**KIRKLEES METROPOLITAN COUNCIL  
INVESTMENT & REGENERATION SERVICE**

**DELEGATED DECISION TO DETERMINE PLANNING APPLICATIONS**

Reference No:	<b>2023/62/93237/W</b>
Site Address:	Brayside, 71, Coach Road, Cowcliffe, Huddersfield, HD2 2NW
Description:	Demolition of existing dwelling and garage and erection of detached dwelling with detached garage
Recommending Officer:	Lucy Taylor

**DECISION – REFUSED**

west elevation garage

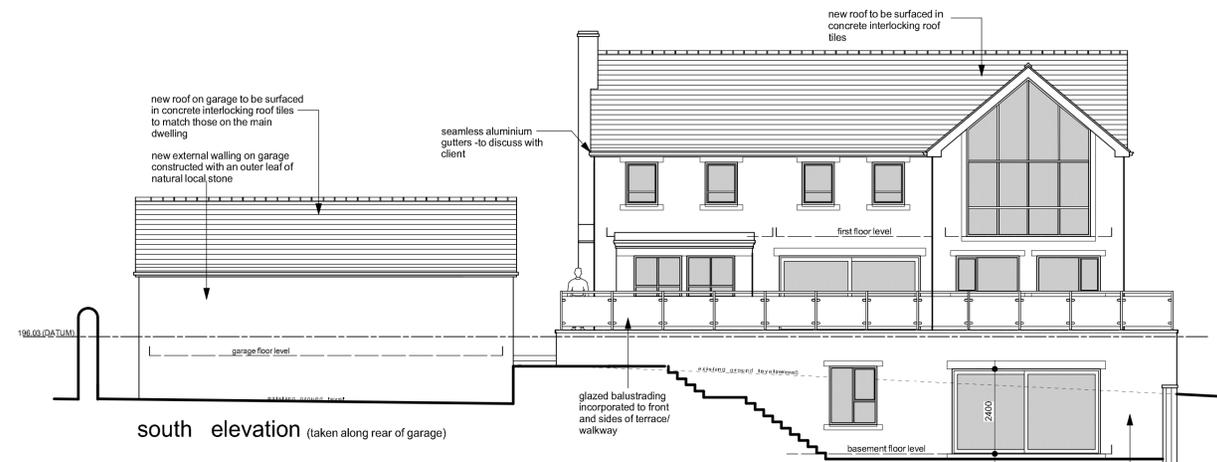
In conjunction with the extent of hard surfacing, the size/scale and siting of the detached garage is considered to be unacceptable from a visual amenity perspective. Adding a significant extent of additional built form within the wider curtilage of the site, with the western, southern and eastern facing elevations all to be blank and solid stone.

The proposed new dwelling would retain a minimum separation distance of approximately 7.6 metres from the shared boundary with No. 8 Fixby Park Drive and the proposed detached garage would be separated from the shared boundary with this neighbouring property by less than 1 metre (minimum

approximately 0.55 metres) and would have a solid western elevation with a maximum height of approximately 5.5 metres.

The overall impacts of the height of the proposed dwelling are exacerbated further by the significant extent of engineering operations proposed to create the lower ground floor level. This furthers adds to the extent to which the new built form would be read as obtrusive when seen from the perspective of the southern elevation.

The rear elevation of the new dwelling proposed habitable room windows to all levels. The rear elevation of the new dwelling would retain a minimum separation distance from the shared boundary with adjacent undeveloped

north elevation

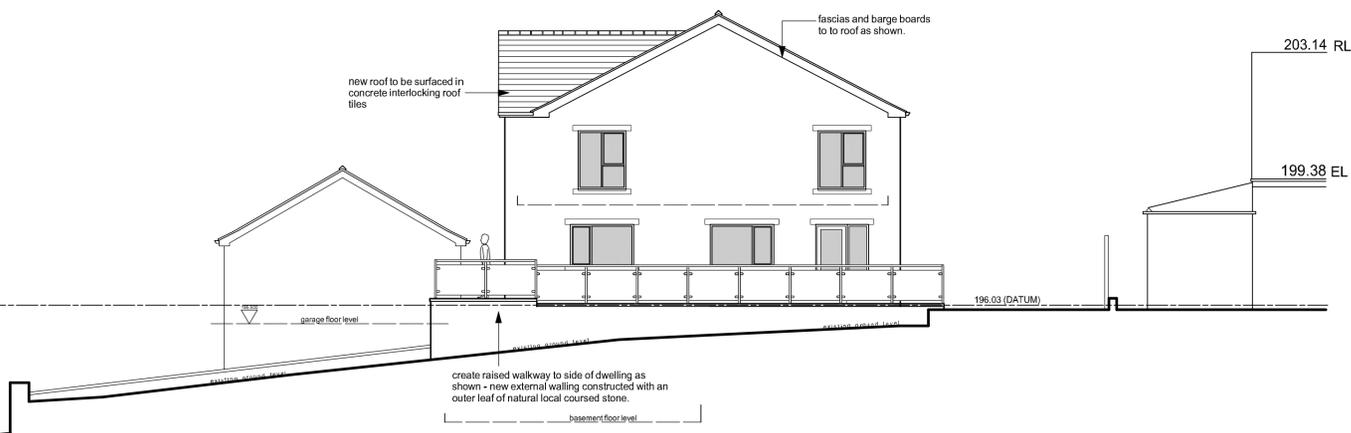
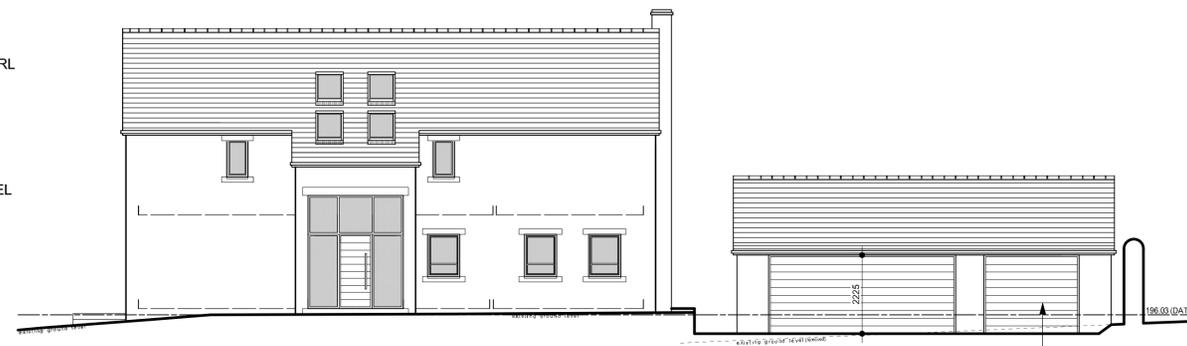
Moving on to the proposed windows and doors, the proposals seek to install a substantial amount of glazing to the front of the new building, with large pieces of glazing dominating the front projecting gable to the north facing elevation and the entirety of the rear elevation. The windows all vary in scale, size and design, appearing sporadically throughout the property. Whilst some more larger panels of glazing could be acceptable within the dwelling, Officers consider the proposals as submitted to appear imposing and entirely out of character and at odds with neighbouring properties, which predominantly have simple windows installed.

The significant amount of glazing further adds to the dominant appearance of the dwelling, and therefore is not considered to accord with Principle 14 of the above SPD.

The front elevation of the new dwelling would be separated from the shared boundary with No. 9 Fixby Park Drive by approximately 3.75 metres, bringing the new dwelling closer to the siting of this neighbouring property than the existing dwelling, with a significant increase in the height, been three-storey and having a ridge height of approximately 8 metres to the north facing elevation.

This reduced extent of separation, in conjunction with the increase in ridge height, is considered to result in undue impacts of overbearing for the occupiers of No. 9 Fixby Park Drive, with a glazed conservatory present to the southern side elevation of this neighbouring property, as well as a first-floor window which appears to serve a habitable room.

The glazing proposed to the first floor of the north facing elevation is not considered to serve habitable rooms internally, with the floor plans showing it to serve bathrooms and the hallway. The glazing proposed to the ground floor would serve the entrance and the study, with guidance setting out that studies are considered to be habitable rooms. As such, given that the proposed windows to serve the study would be separated from the shared boundary with No. 9 Fixby Hall Drive by approximately 4.4 metres and from the siting of the conservatory at No. 9 by approximately 6.3 metres, it is not considered that these windows are compliant with the recommended separation distances within the Housebuilders Design Guide SPD and therefore, could result in undue impacts of overlooking.
